Ecology response

From: Jonathan Best <Jonathan.Best@arun.gov.uk>
Sent: 27 January 2025 09:56
To: Planning.Responses <Planning.Responses@arun.gov.uk>
Cc: Simon Davis <Simon.Davis@arun.gov.uk>
Subject: AL/143/24/RES

Land adjacent to Woodgate Nurseries Lidsey Road Aldingbourne PO20 3SU.

TITLE PRELIMINARY LIGHTING DESIGN

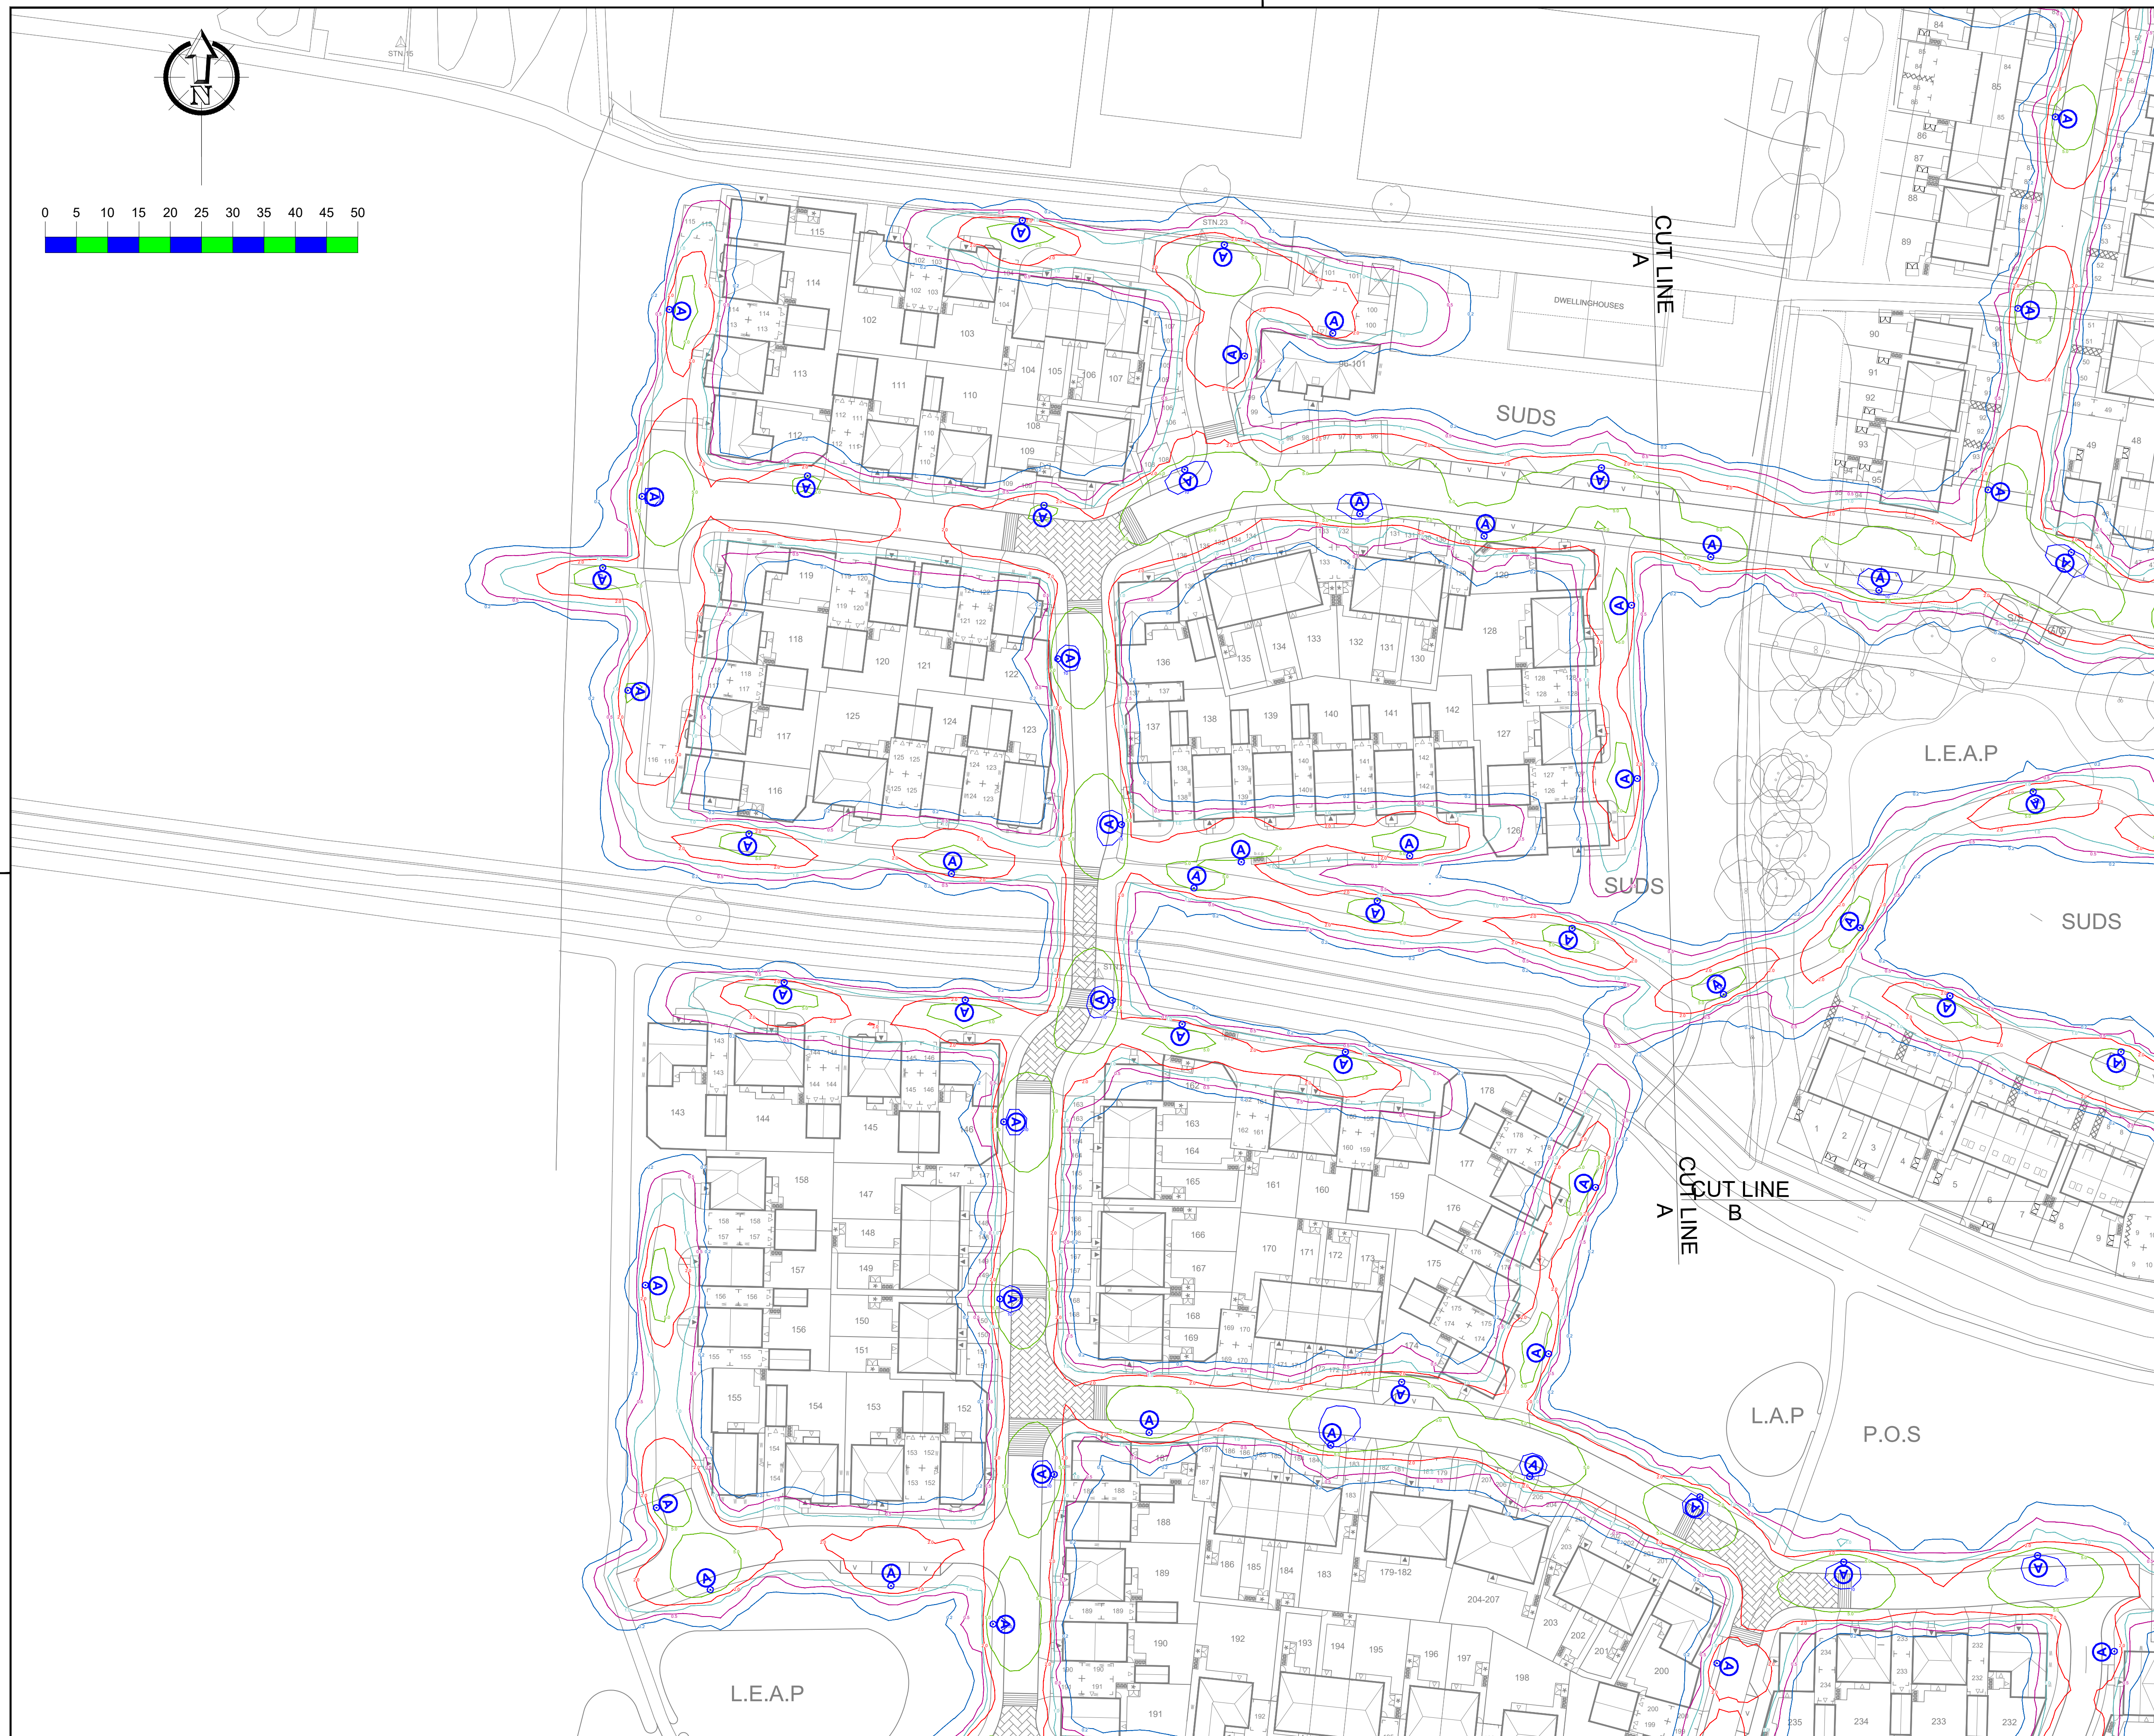
The Lighting Plan is fine and meets best practice for bats.

Title: Play and Open Space Proposals Sheet 3

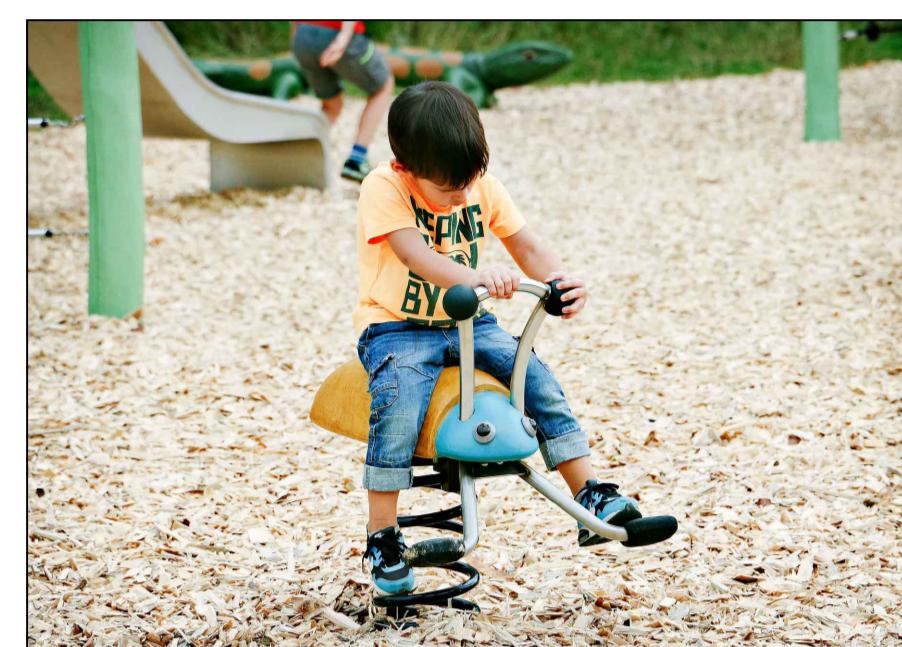
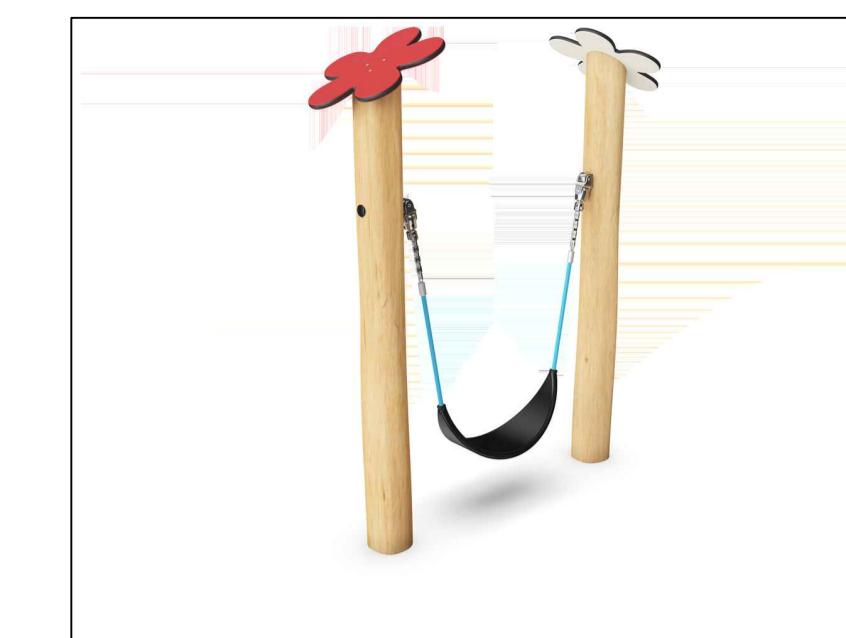
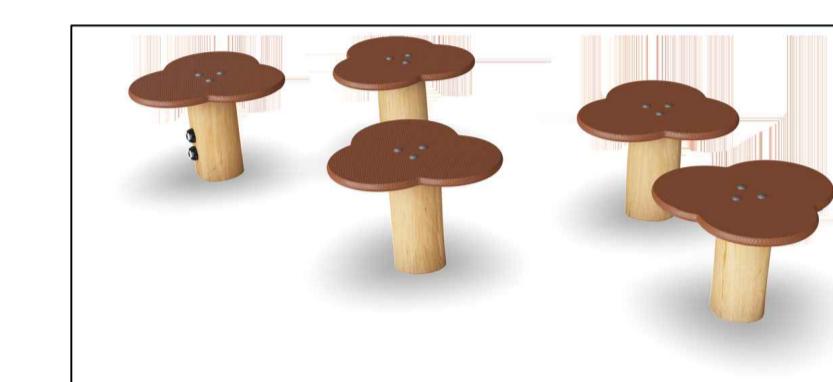
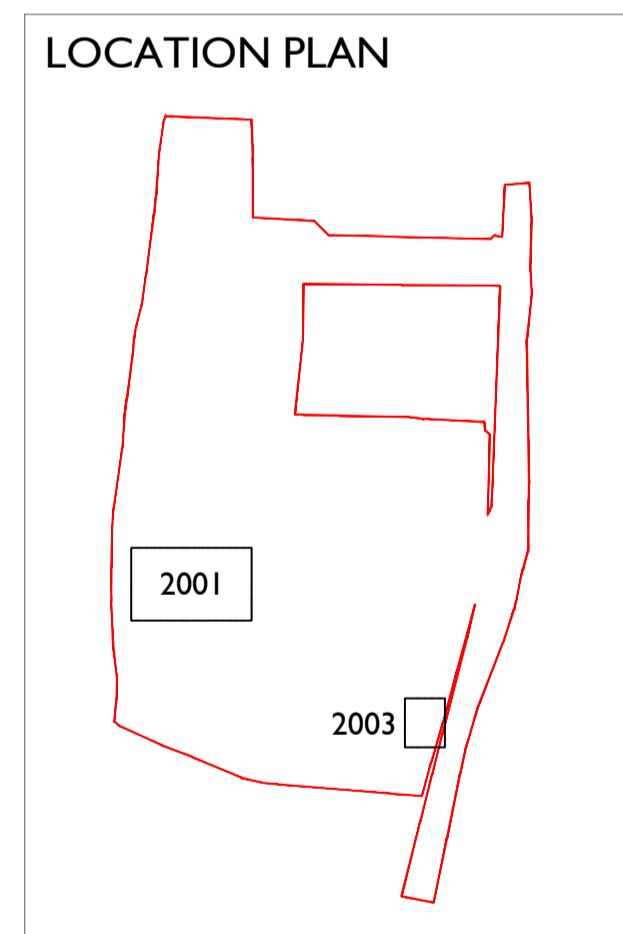
The native hedgerow species mix proposed in the Play and Open Space Proposals Sheet 3 do not meet the requirements of the EIA. There is no Hawthorn, and the mix only contain 4 species in total instead of the six required.
